From: Liz Hutchings 
Sent: 06 March 2018 08:46
To: Amber Willard
Subject: FG/115/17/PL Revised plans

Elisabeth Hutchings
42 Ferringham Lane

DWG No. 628-03 rev. C

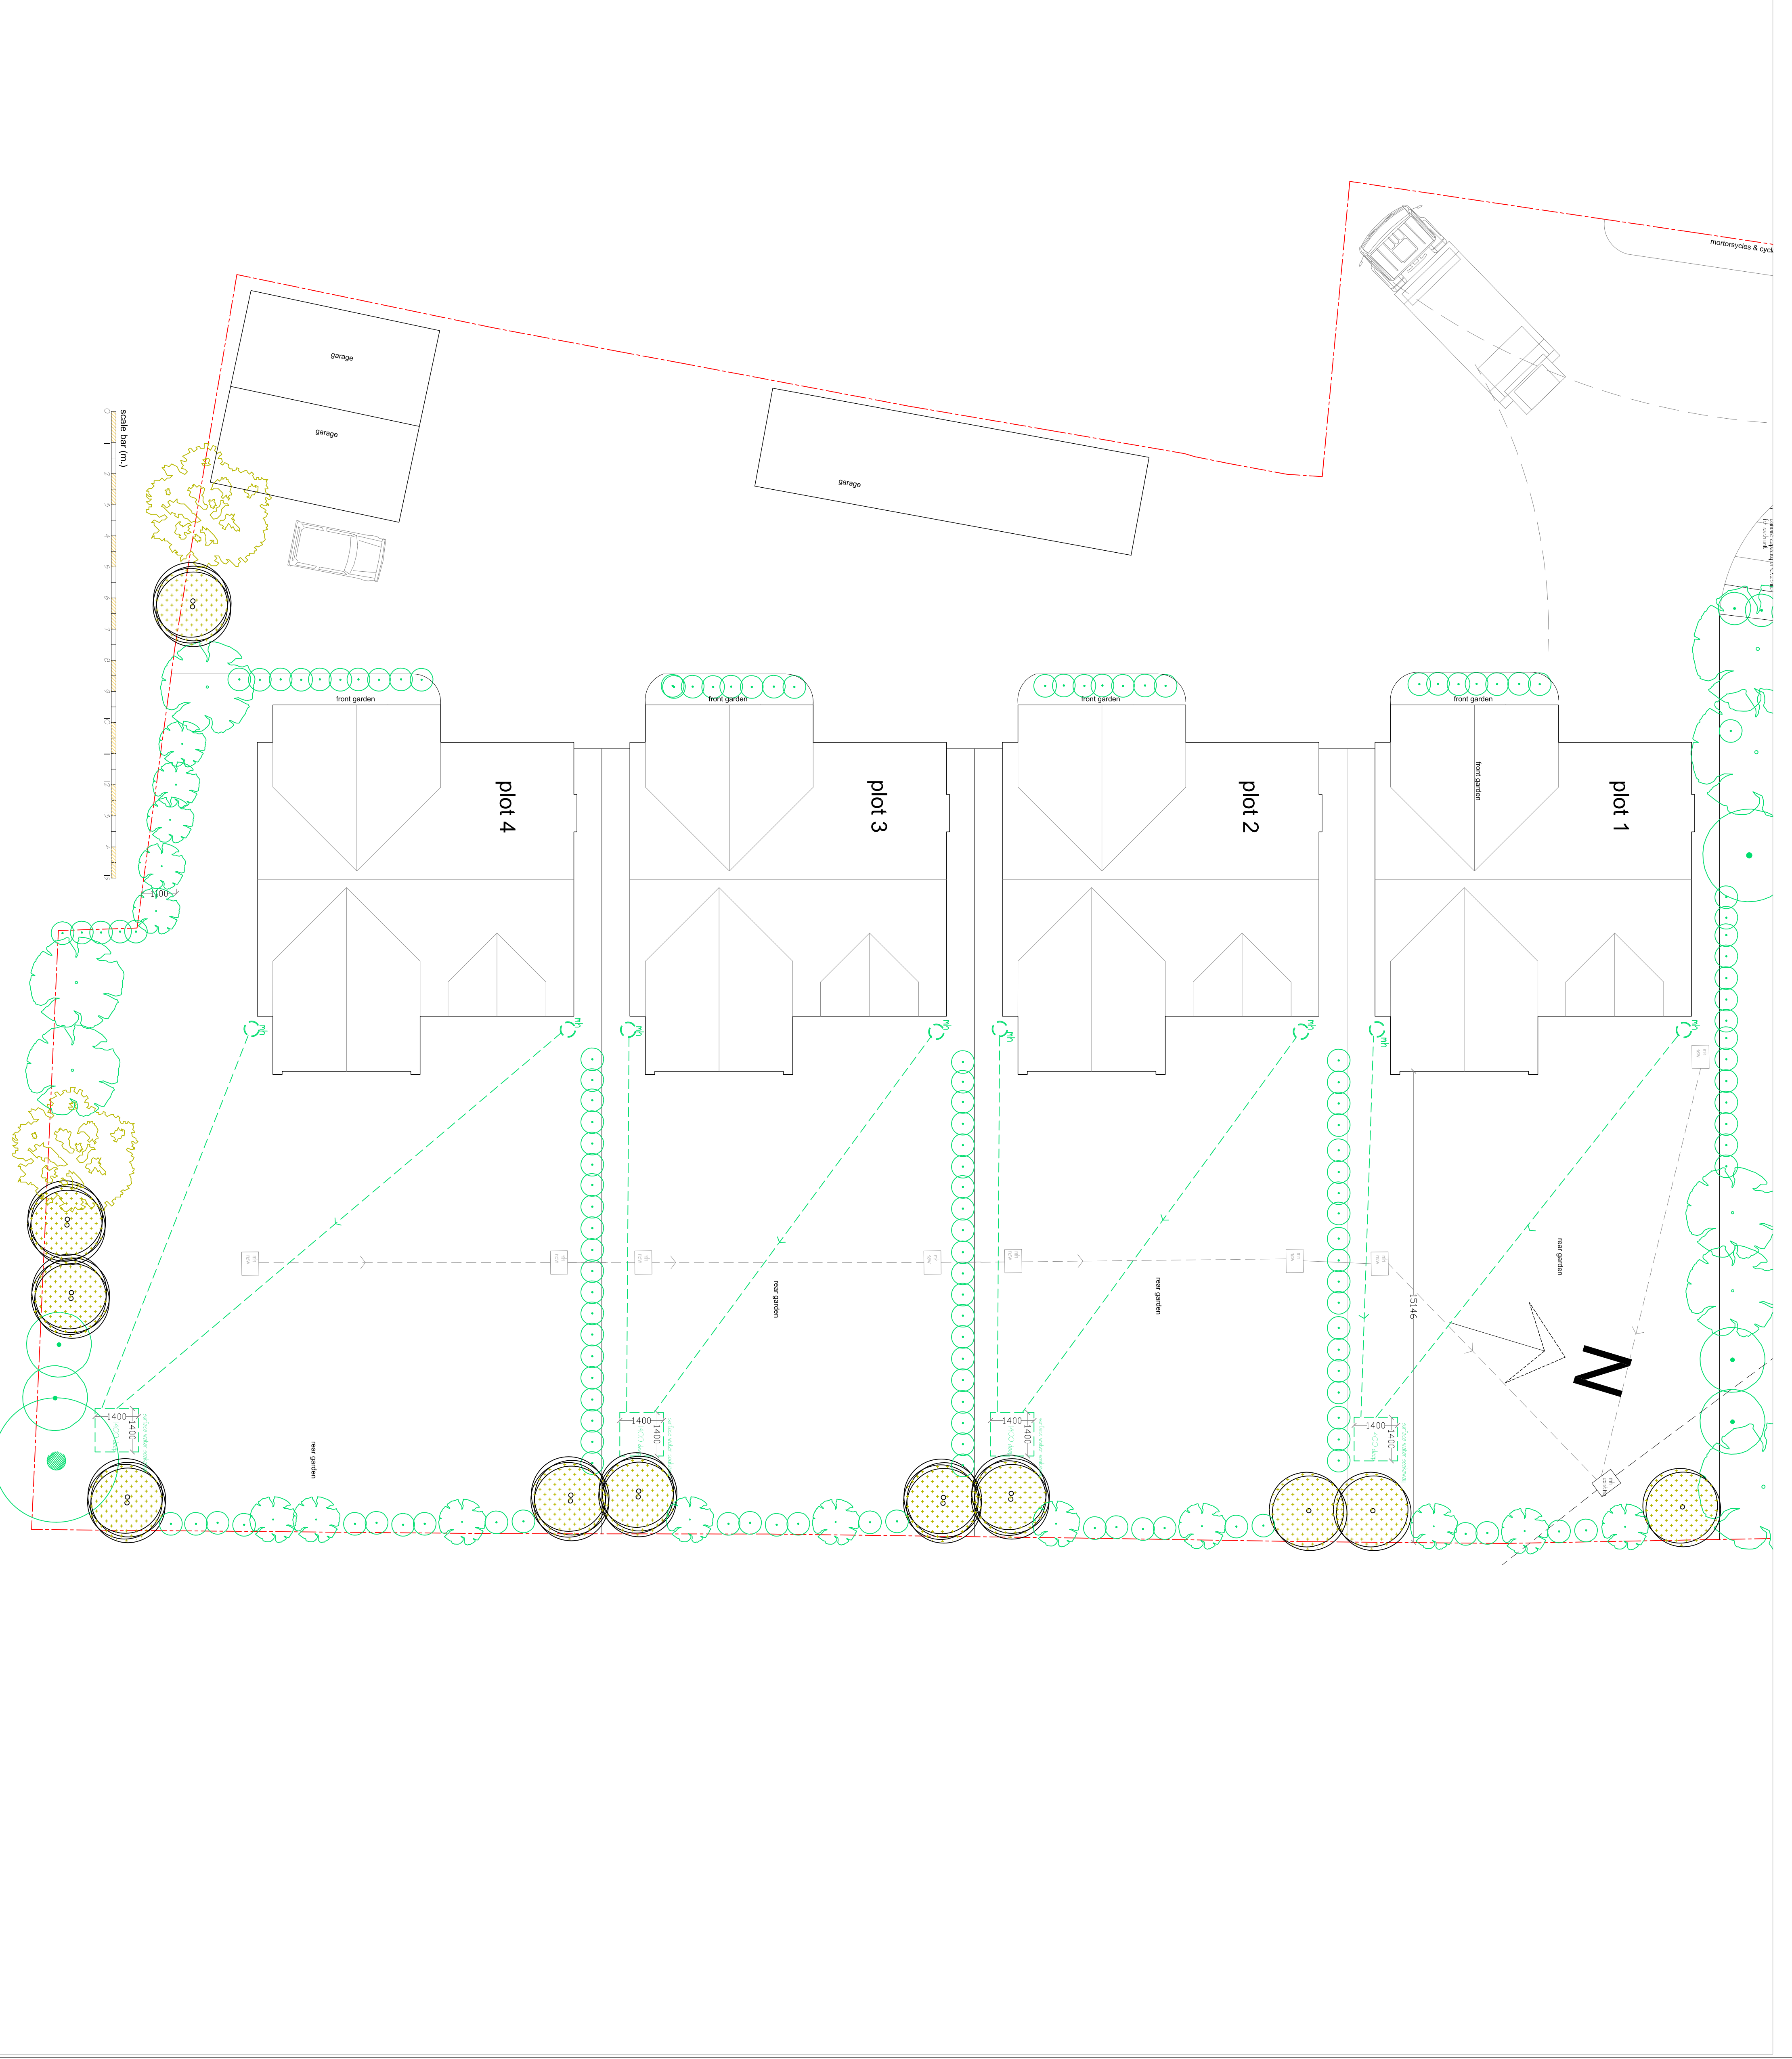
2. County Highways appear more concerned with plans for the turning circle within the cramped development site, that further impedes on the already inadequate parking allowance, than the safety of all the Ferringham Lane highway users.

A turning circle at the road end of the single track access that allows vehicles to enter and exit the site without reversing or crossing into the path of oncoming vehicles should be of more importance as it will affect all road users.

3. A guaranteed shortage of parking within the development will lead to overflow on street parking along the lane and force pedestrians to walk in the road. For the school children and the less able this will be hazardous as the pavement along here is now minimal and the current 30mph limit is not marked or adhered to.

This on street parking will also impede future residents therein who will have no guaranteed visibility splay when entering or leaving or this very reason. It will not be safe to exit in these conditions for anyone.
